Objection to Planning Application 2025/62/92897/W – 49 Bank End Lane, Huddersfield HD5 8ES

title  
Elevations - As Proposed

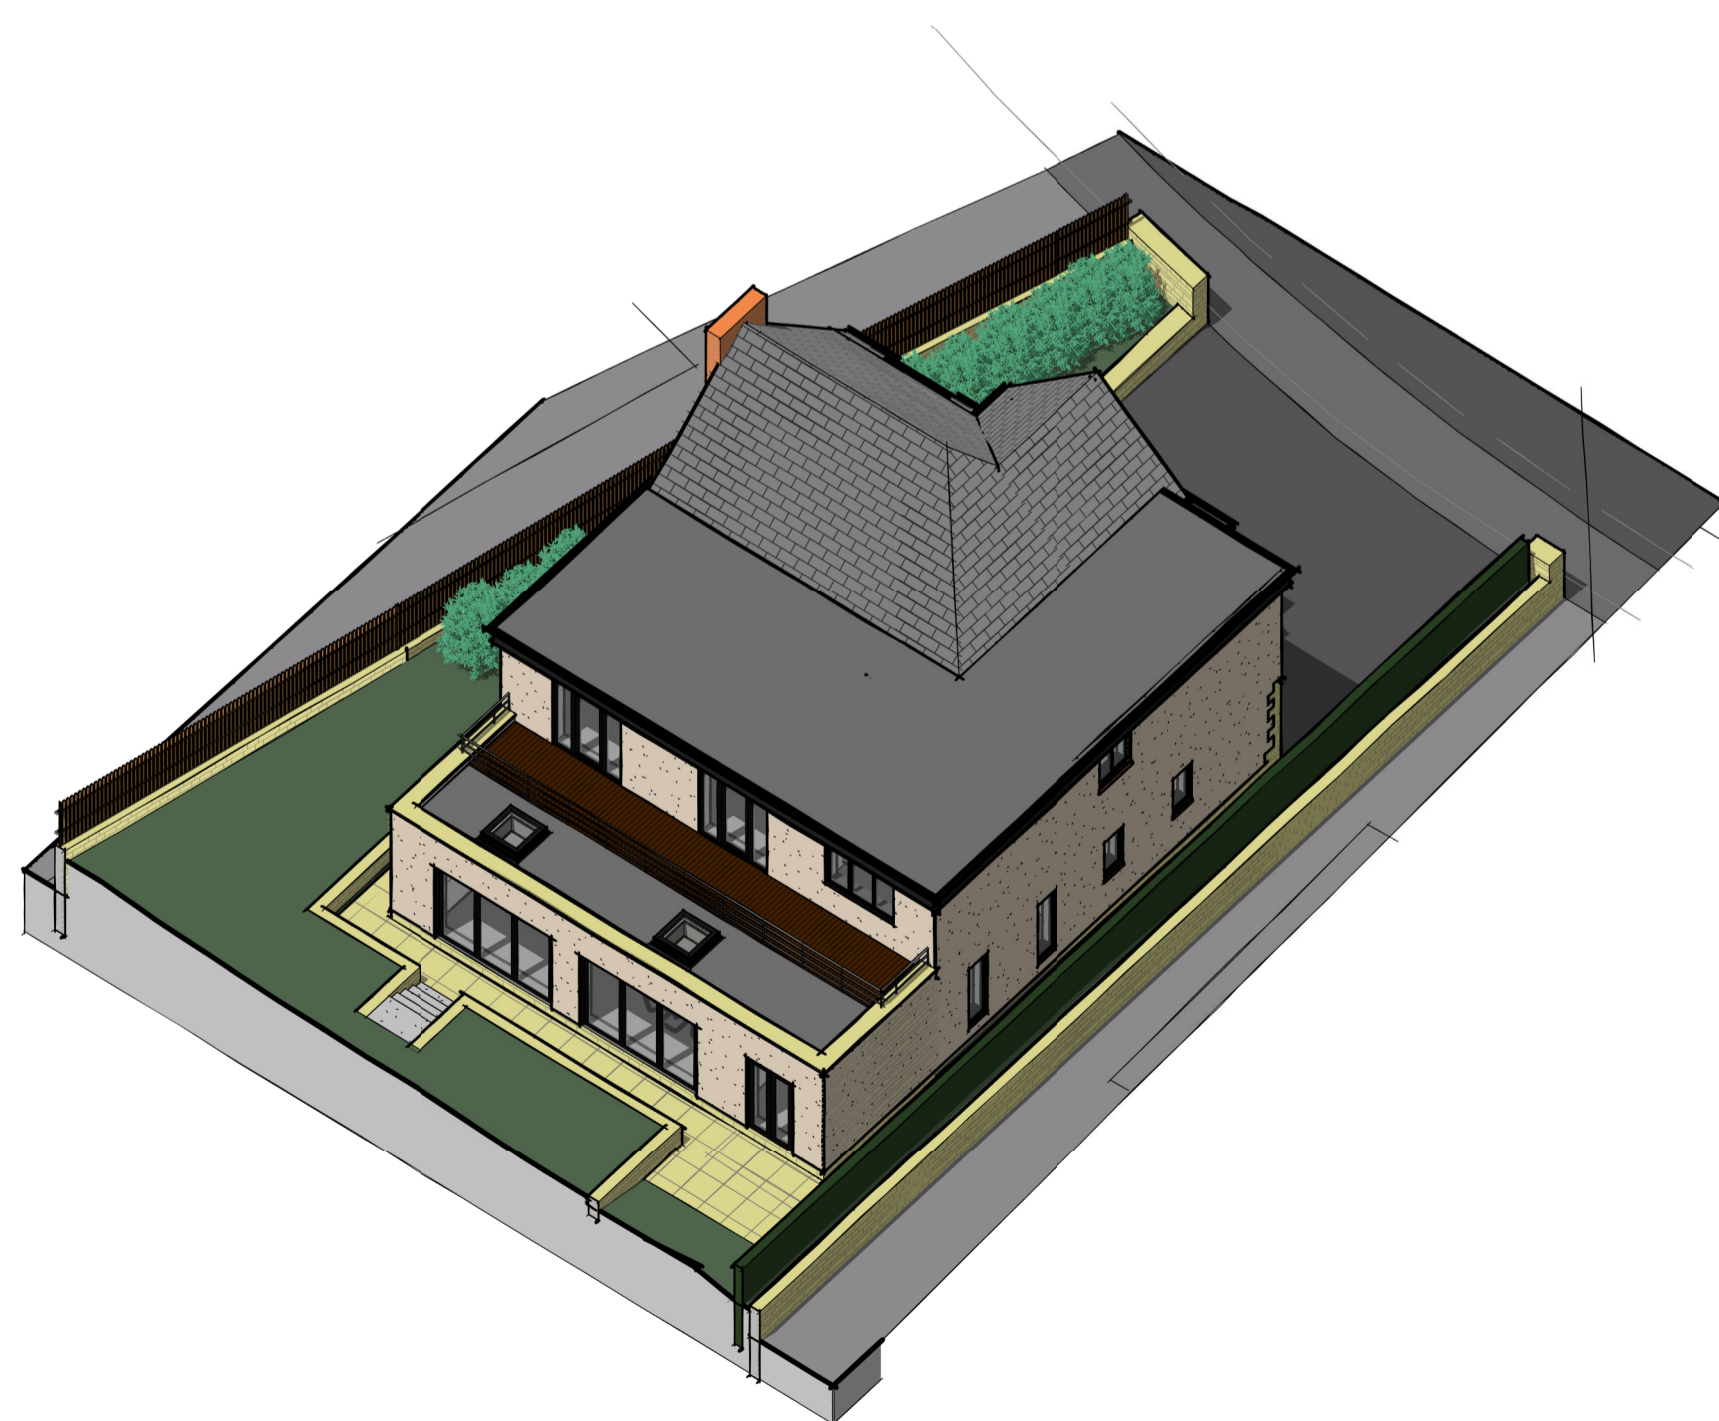
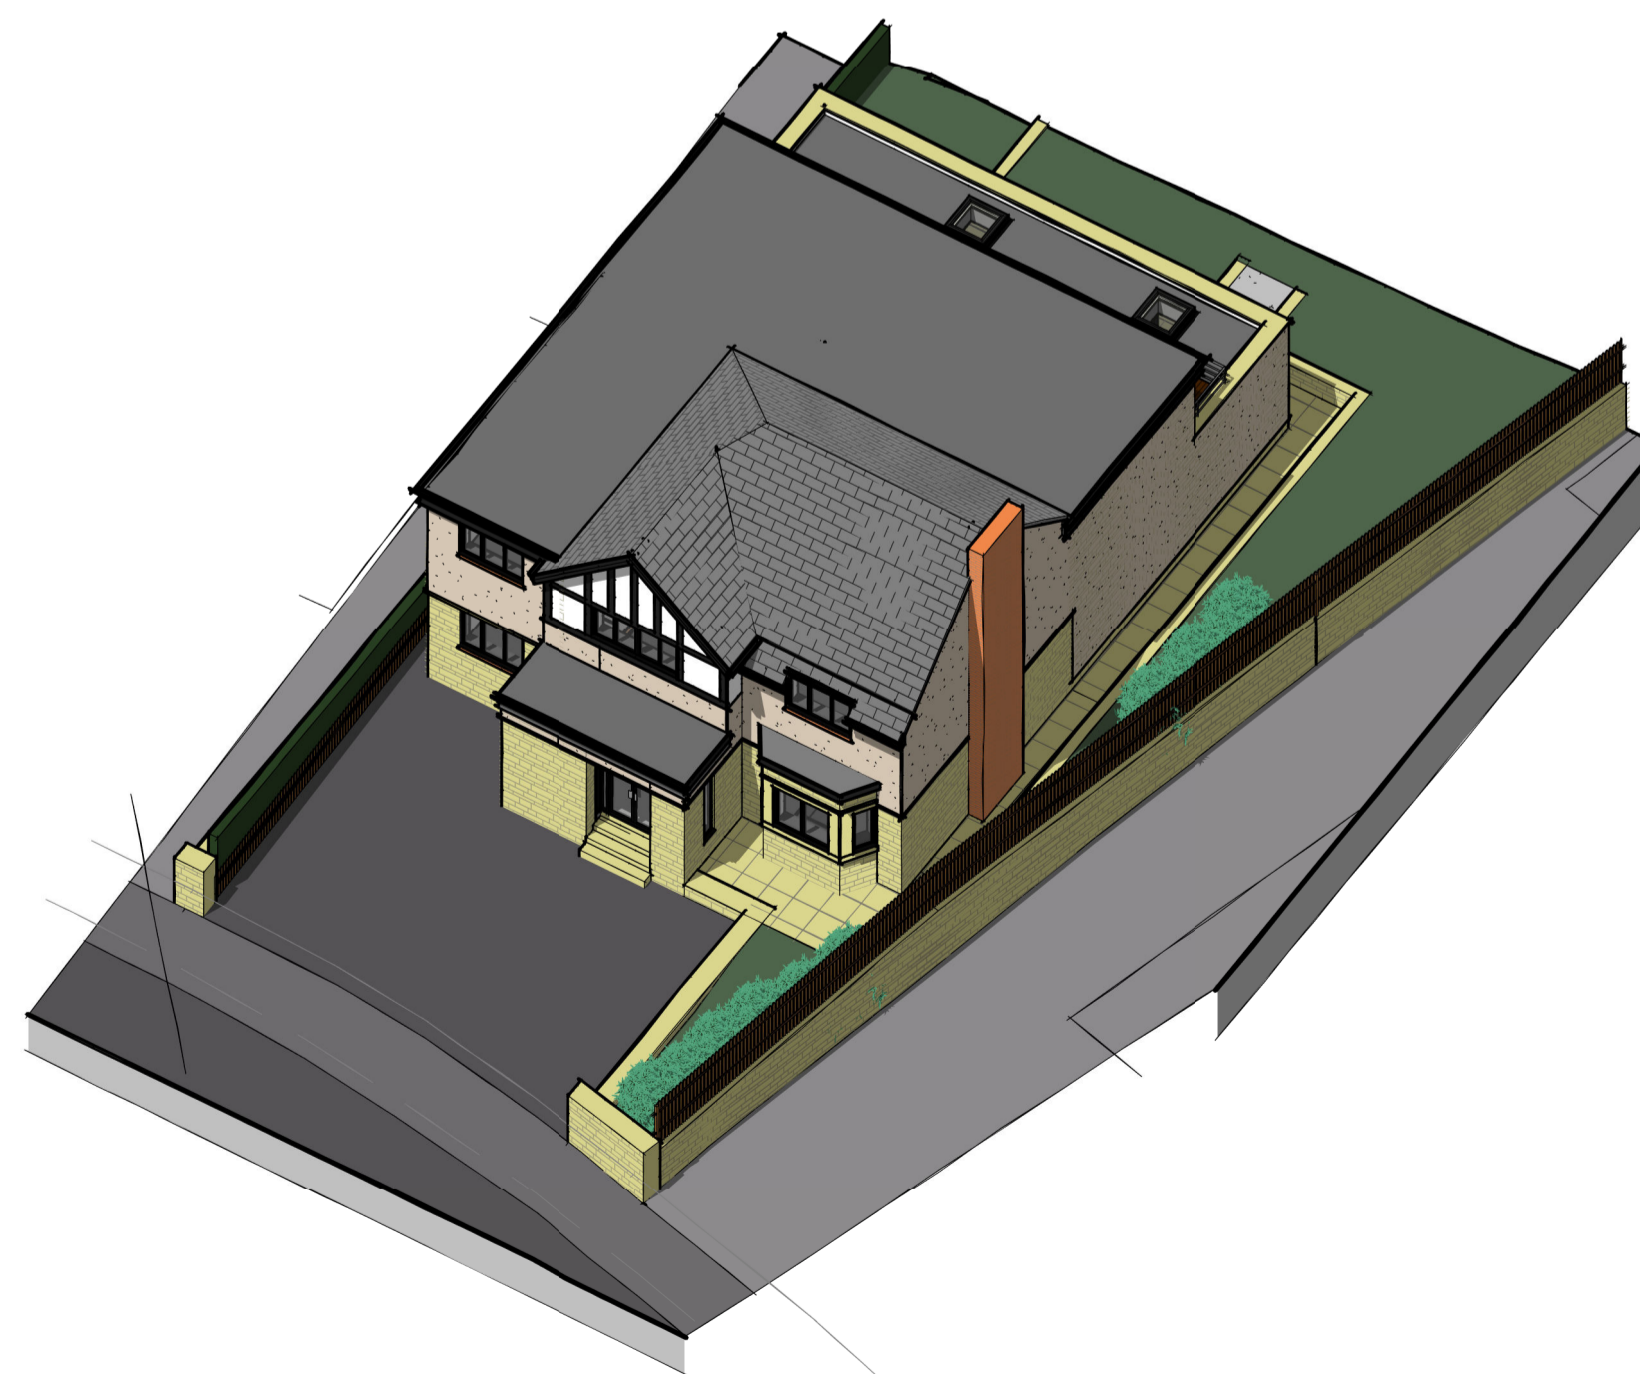
The vast size of the proposed extension, together with making it a two-storey extension will directly overlook my property, resulting in a significant loss of privacy. The proposed balcony will be in extreme proximity to my bedroom window, and given the extension is proposed to end one metre from the existing boundary, will extend a considerable distance further back compared to the rear of my property, and – because of the topography – is situated on higher ground than my property, it will also block natural light into my home and garden, reducing my enjoyment of the space. The report suggests that the applicant has suggested that a flat roof will minimise the impact on residential amenity and light. However, a two-storey extension that extends so close to my property, and as far back as the proposal will have far more impact than the choice of roof pitch.

The scale and positioning of the development are disproportionate to the surrounding properties. Whilst other local properties have extended sideways, this application expands the property significantly on three sides. Also, as an _____, who has lived in my property since _____, I do not wish to have my final years feeling as though I am overbearingly overlooked by a neighbouring property, especially by a balcony that will be practically outside my bedroom window. The proposed extension will do just that, and is an unrealistic proposal. The Cadvis3D report states that

The character of Huddersfield's residential areas are valued for their balance of heritage and community feel. This proposal is out of keeping with the established character of the street and risks setting a precedent for inappropriate development. From the kerbside the proposed side extension is not remotely in keeping with similar developments in the area, which have seamlessly been incorporated into the existing structure. In addition, the plans show how from certain angles, almost nothing of the original property is visible.
